343-D-2
19980059
181 Allen
Ave.

Garage
w/ 3 family

Re: 181 Allen Avenue

On June 25, 1998 the Portland Planning Authority granted minor site plan approval for a garage with an apartment at 181 Allen Avenue with the following conditions:

GOFF PLOT PLAN

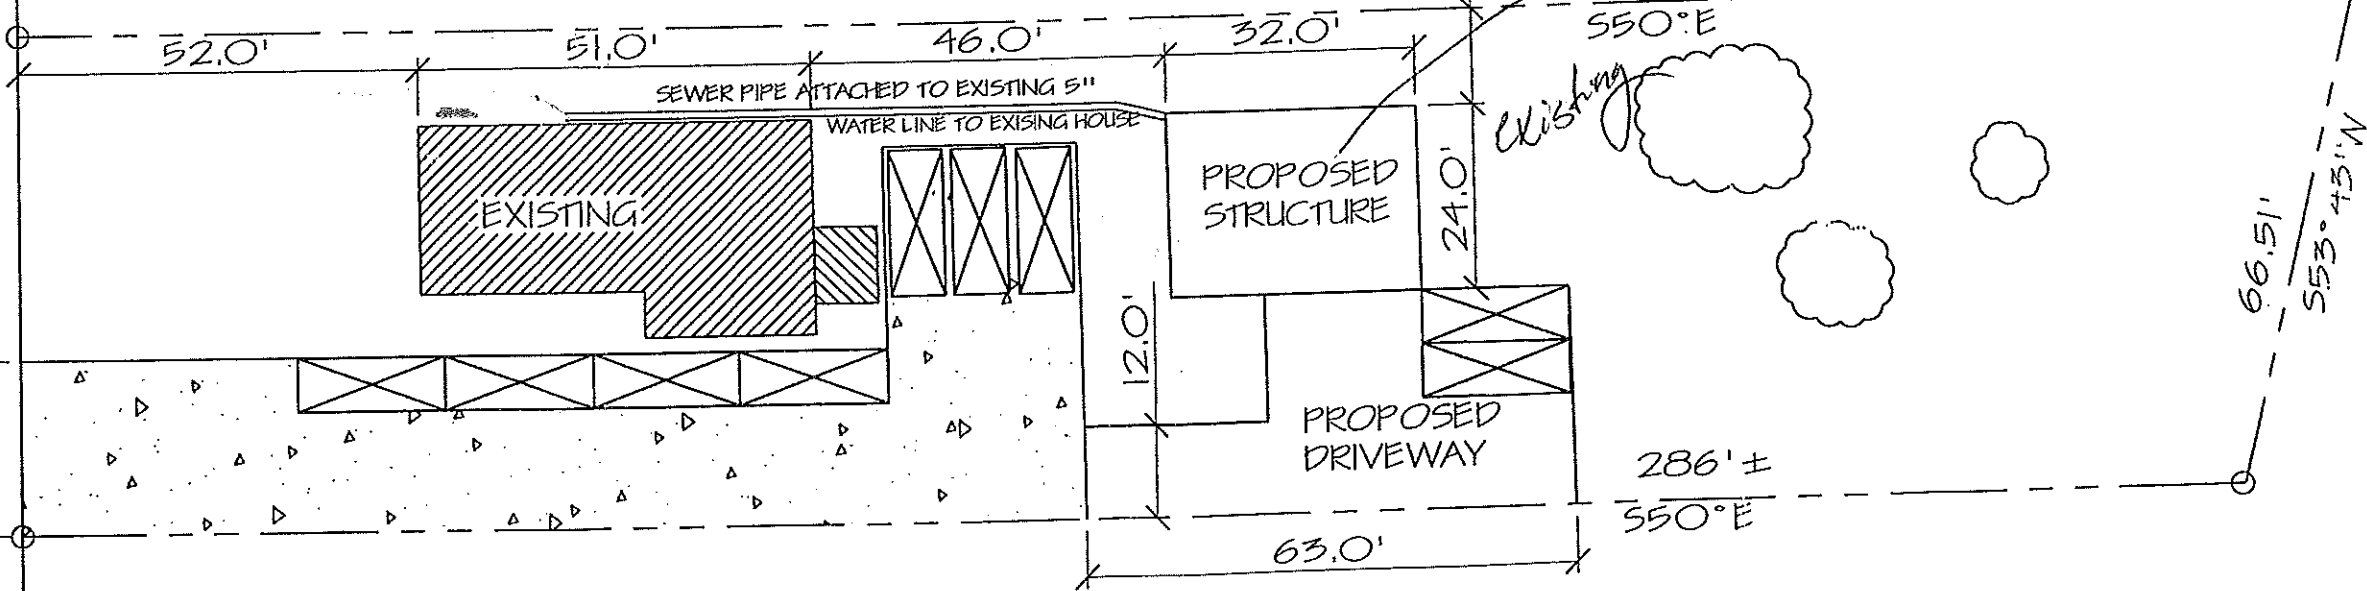
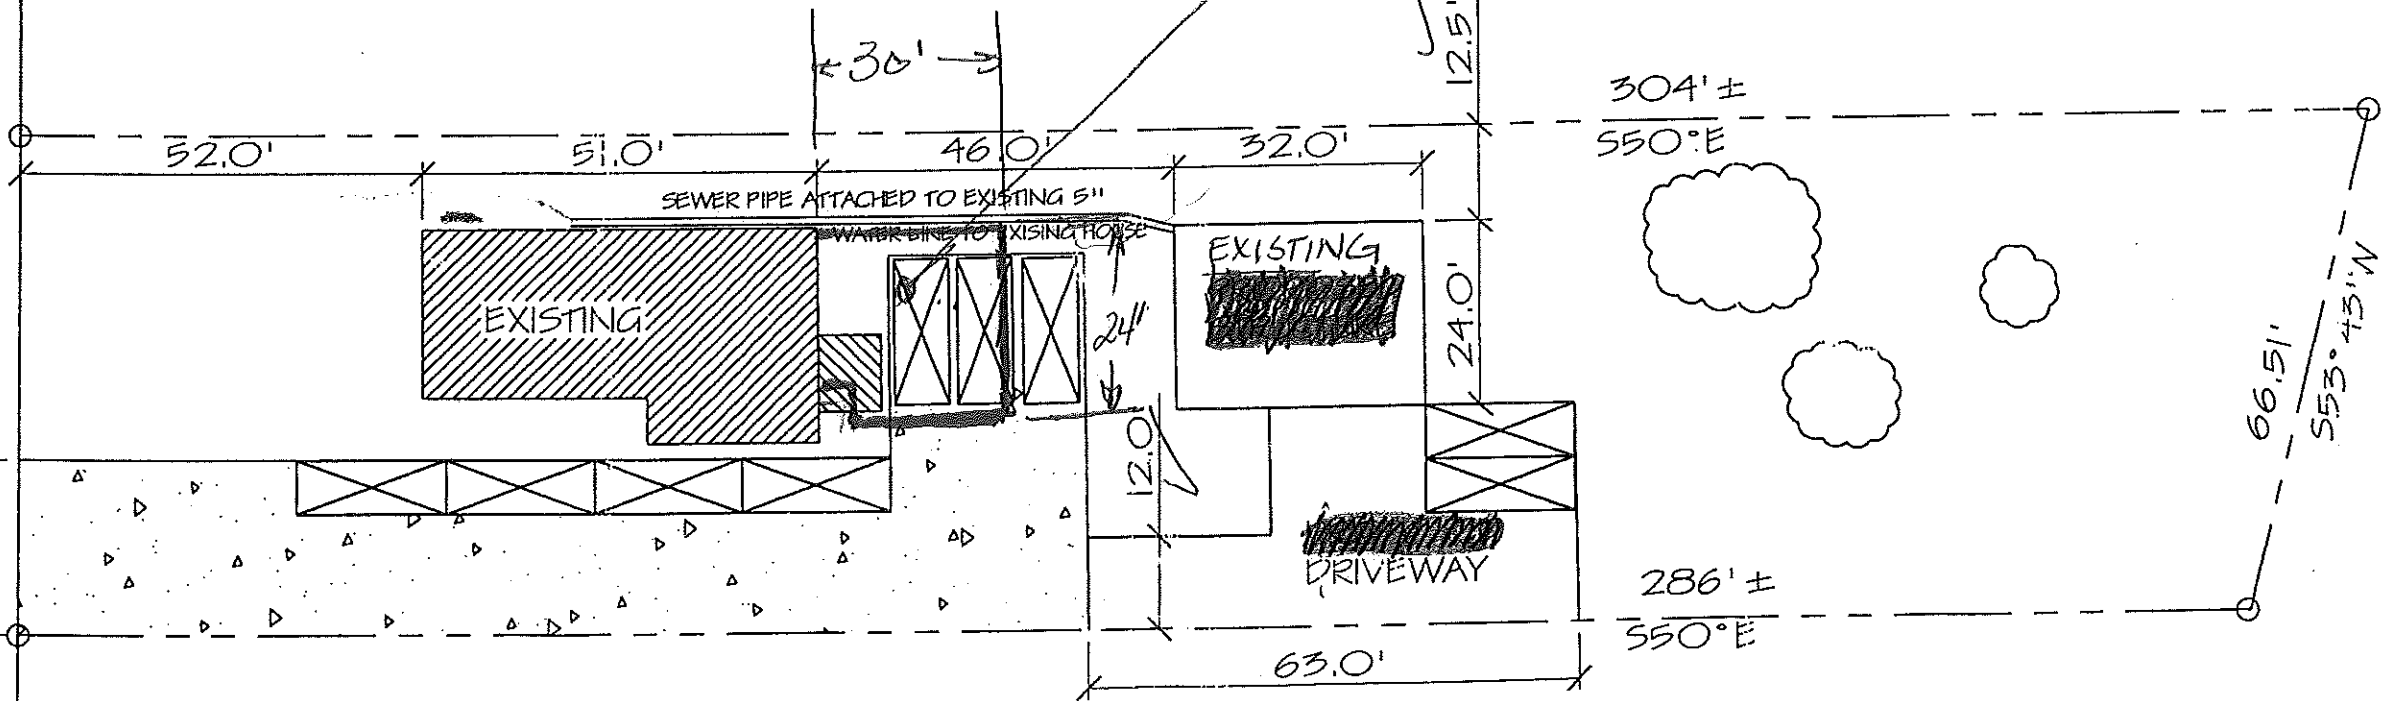
- i. The approximately 3' high retaining wall along the western property line shall be a "keystone" style pined concrete block wall located a minimum of 1' from the property line. It shall be installed per the manufacturer's technical requirements.

- ii. The proposed trench drain in front of the garage doors shall discharge the flow onto a riprapped apron in conformance with "Maine Erosion and Sediment Control Handbook for Construction: Best Management Practice"

- iii. A, 5' by the full width of the drive, riprap apron shall be placed at the end of the proposed drive; it shall conform to the referenced handbook noted above.

- iv. The grading of the drive shall contain the storm runoff within the site.
- v. Silt fence shall be installed prior to any construction and shall be installed down gradient of all disturbed areas.
